# ENG-CDR20005-R2-GEC-Redlines.pdf Markup Summary

005 / SF-20-015

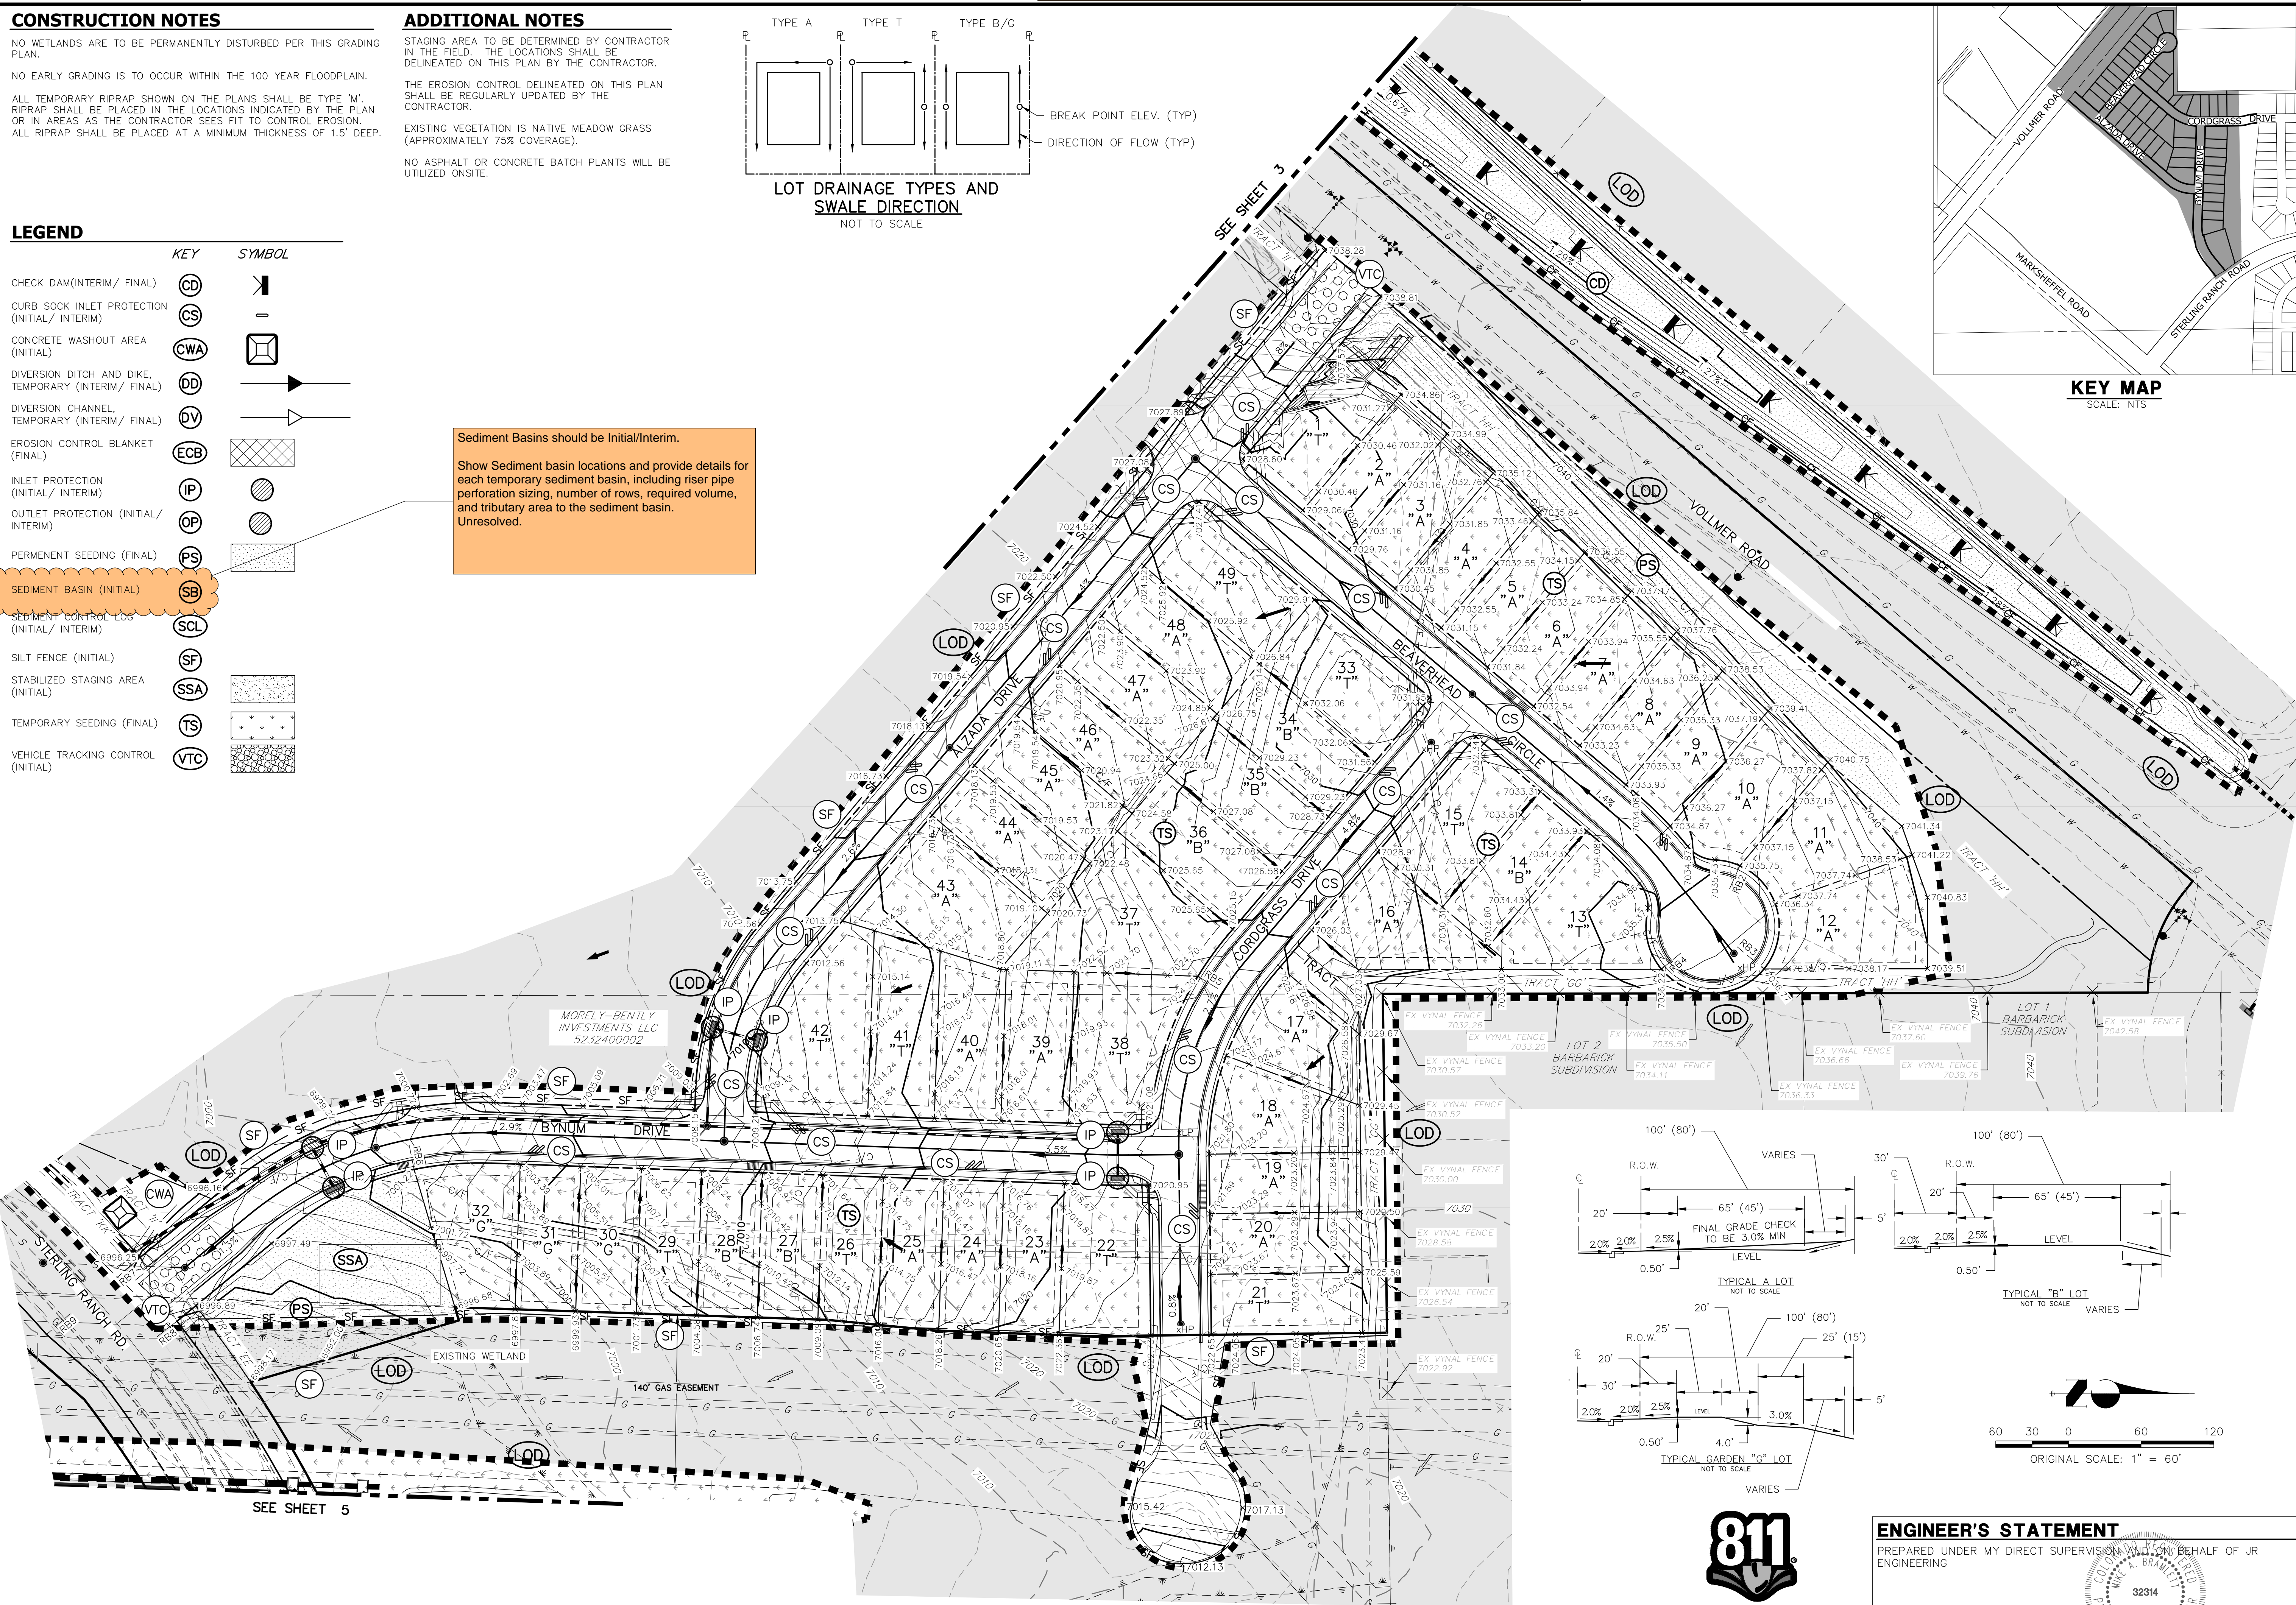
Sediment Basins should be Initial/Interim.

Show Sediment basin locations and provide details for each temporary sediment basin, including riser pipe perforation sizing, number of rows, required volume, and tributary area to the sediment basin. Unresolved.

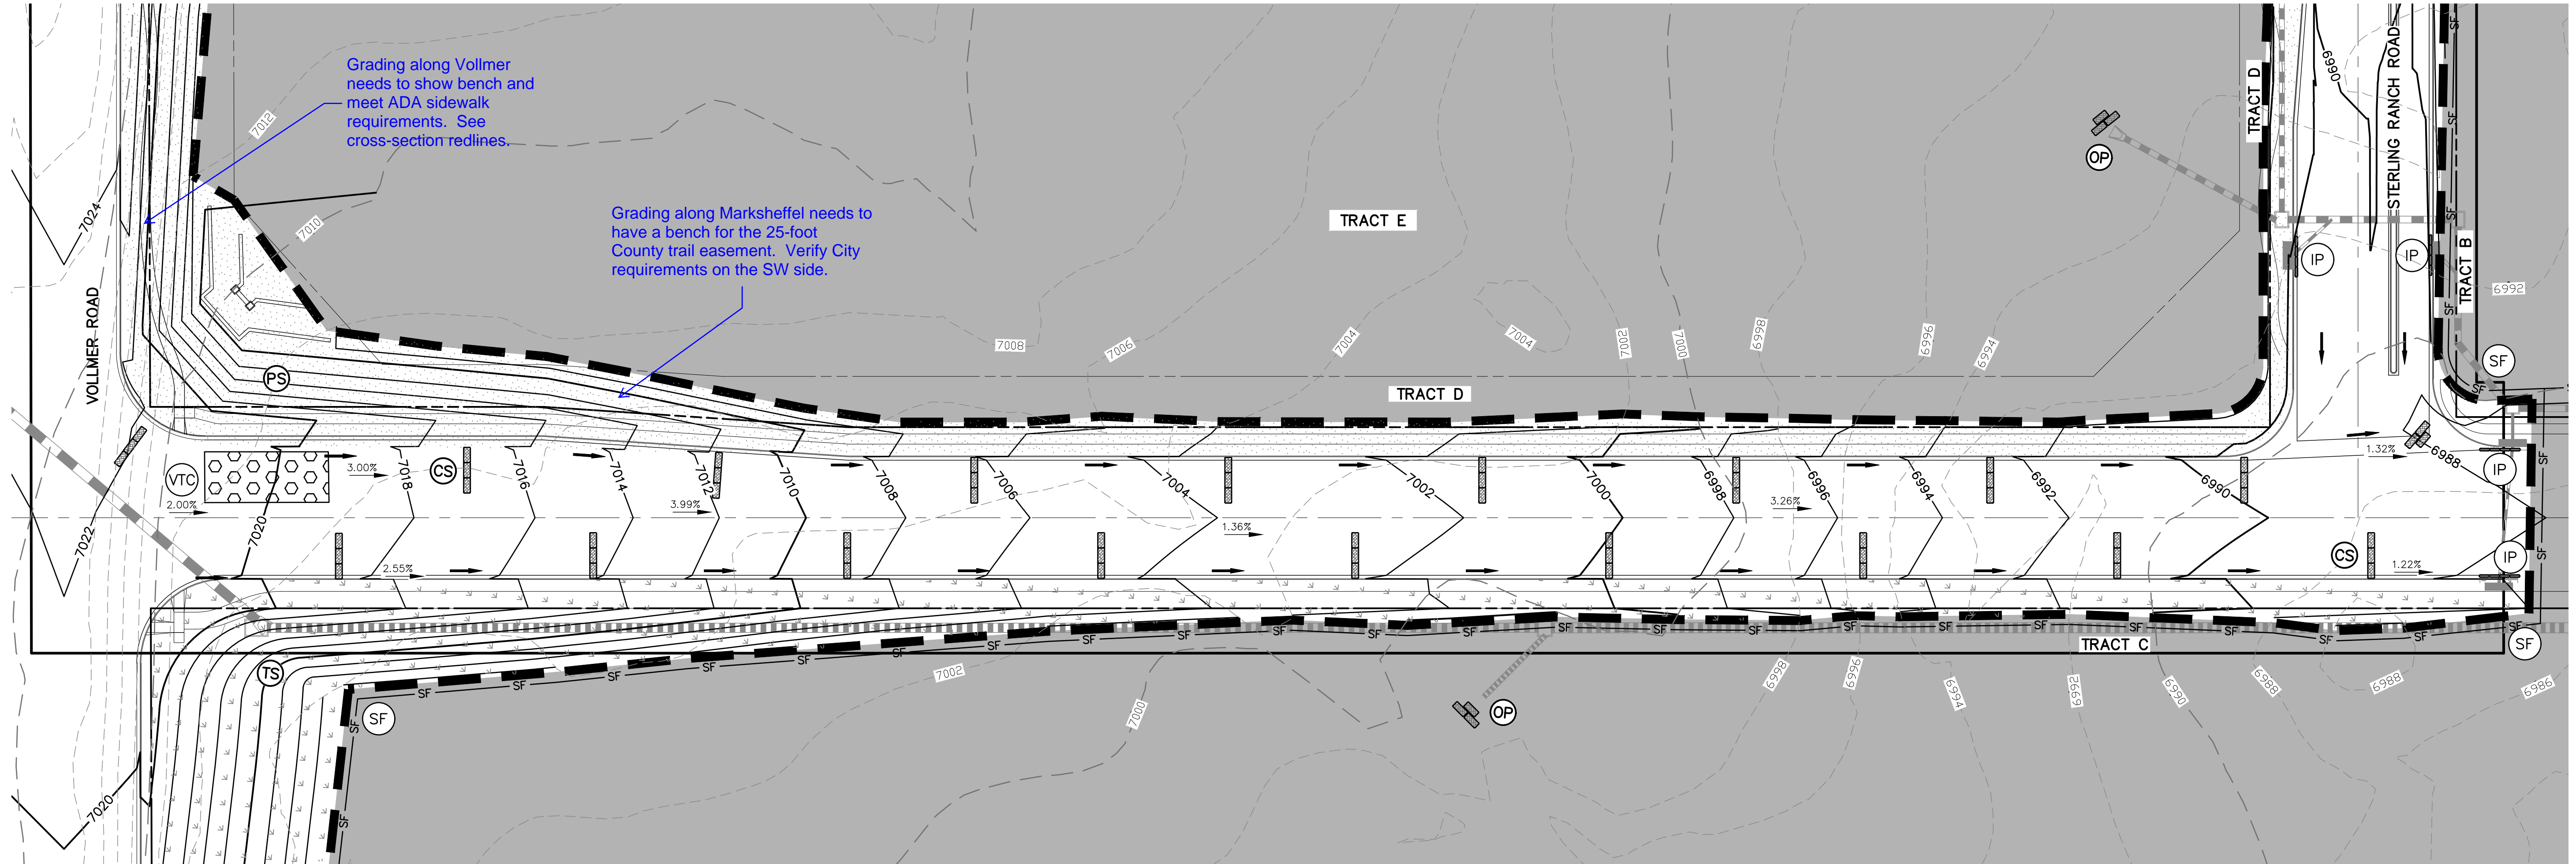
Show the existing emergency access road that needs to remain unobstructed or otherwise relocated during construction.
